**Hartfield Place SHD
Engineering Services Report
for
Strategic Housing Development Application
at Swords Road, Whitehall.**

Doc No. HARTPL-JOR-SM-ZZ-RP-C-9001_D

The below report contains responses to items raised by DCC drainage division on the 4th of November 2021 for a proposed SHD application at Hartfield Place, Swords Road, Whitehall, Dublin 9.

ATTENUATION TANK 1 - FLOOR PLAN
SCALE: 1:100

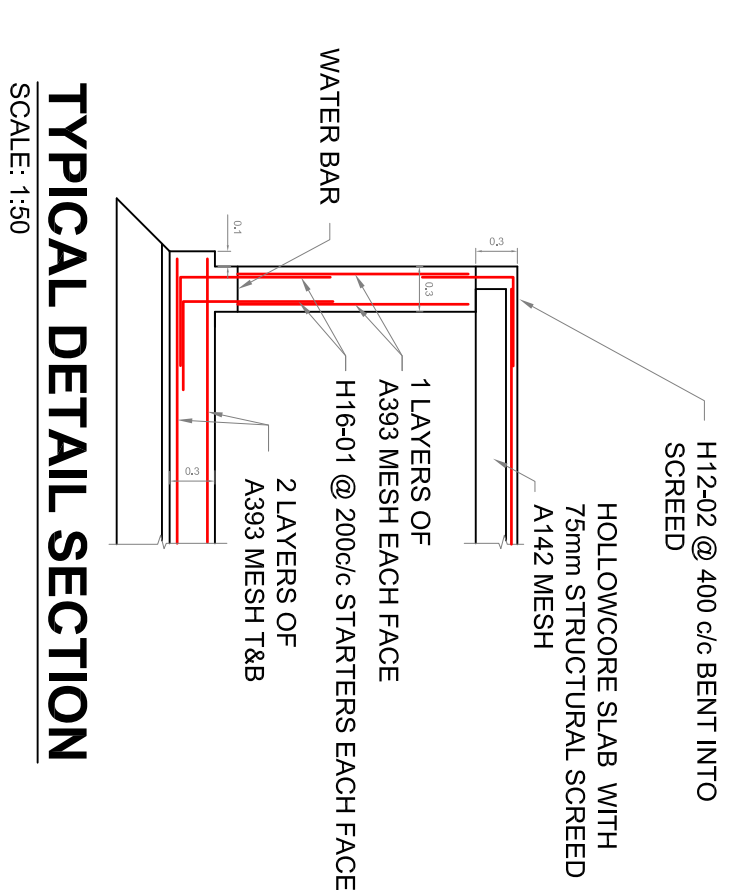
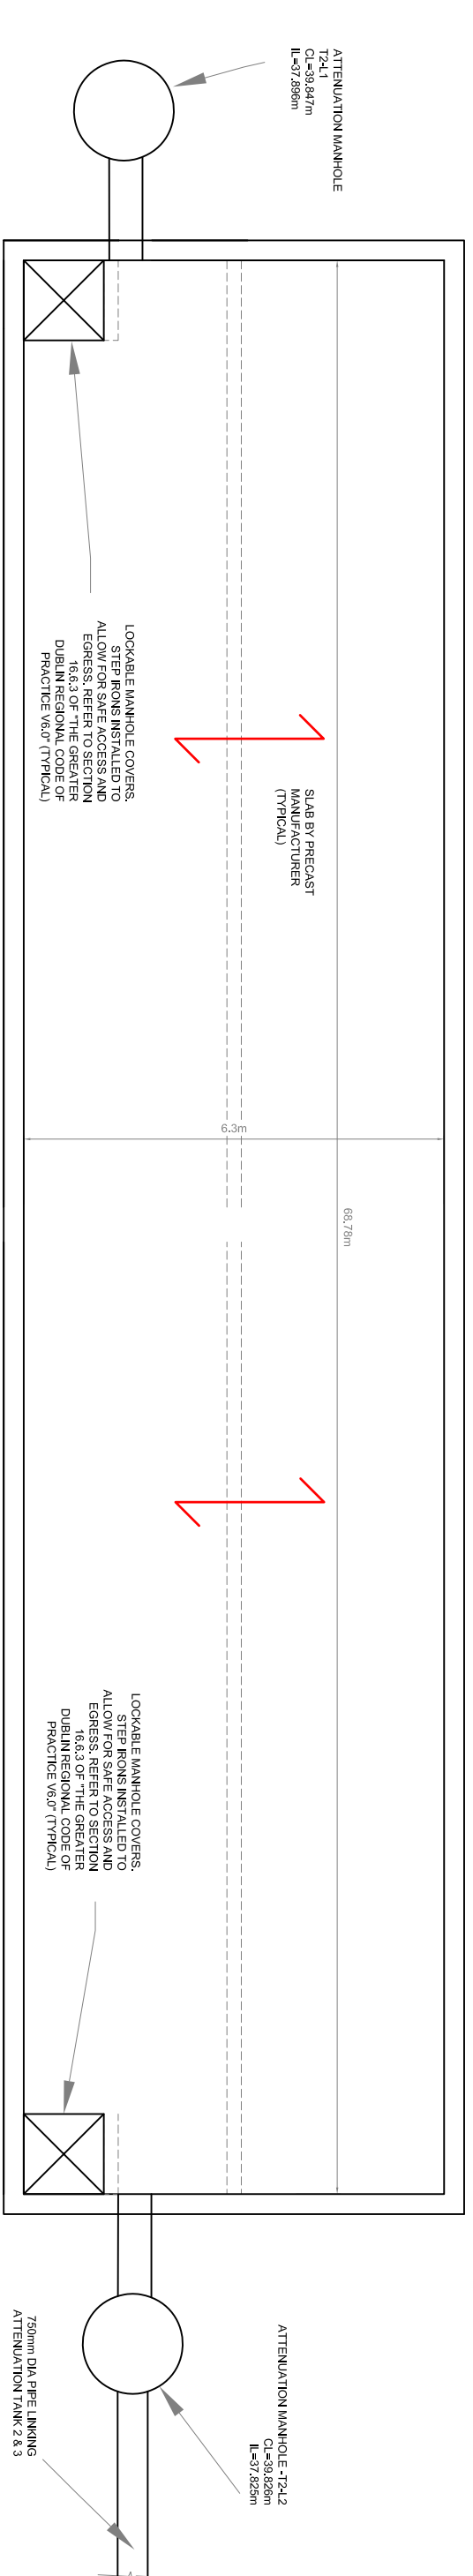
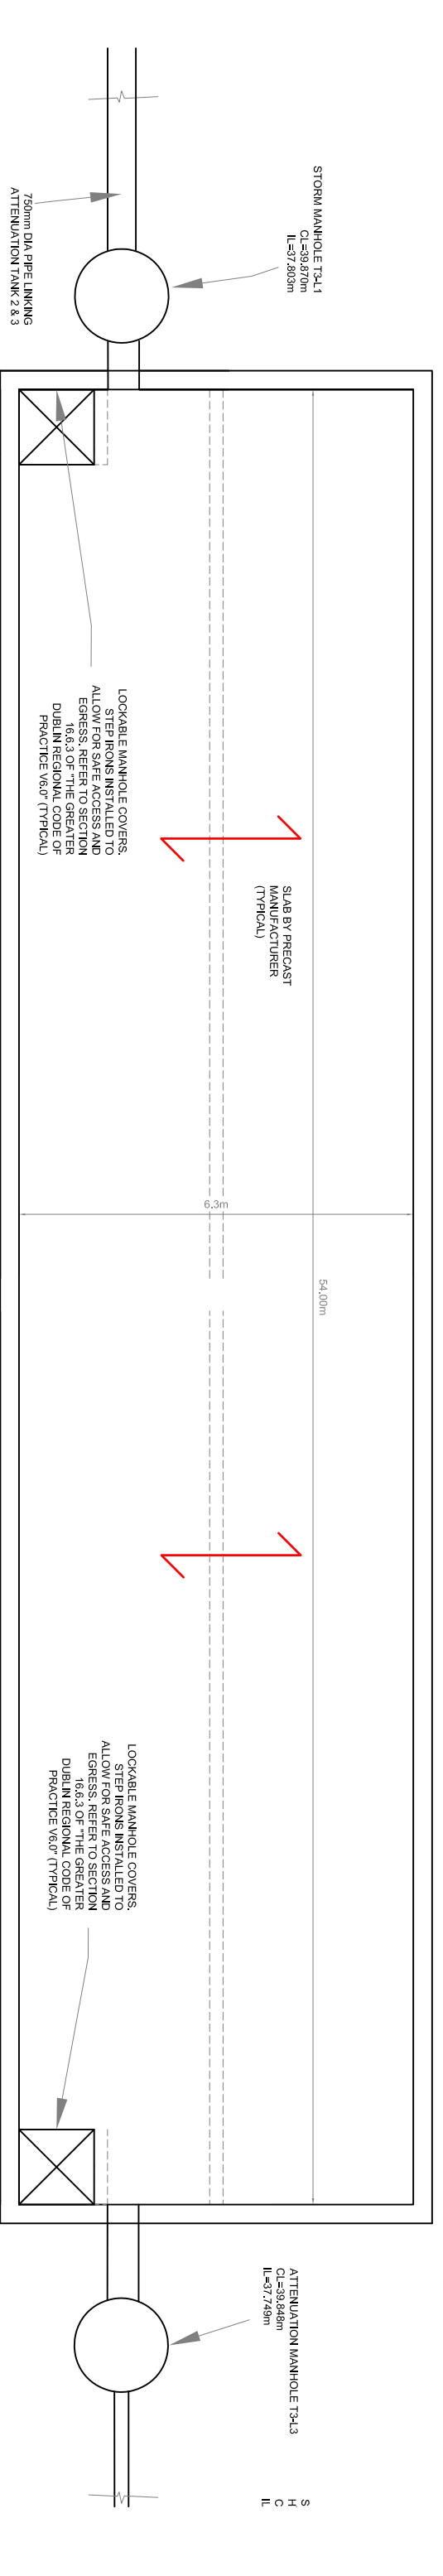
In relation to the proposed attenuation tank, where there is available open space DCC's preference is for natural storage mechanisms such as ponds, detention basins etc. Only where these are shown not to be feasible will DCC accept an underground attenuation tank. Detail to be revised to meet the following –

Bio-retention basins/ ponds were considered for the subject site but on review, the area required for a bio-retention basin/ pond would severely reduce the available public open space.
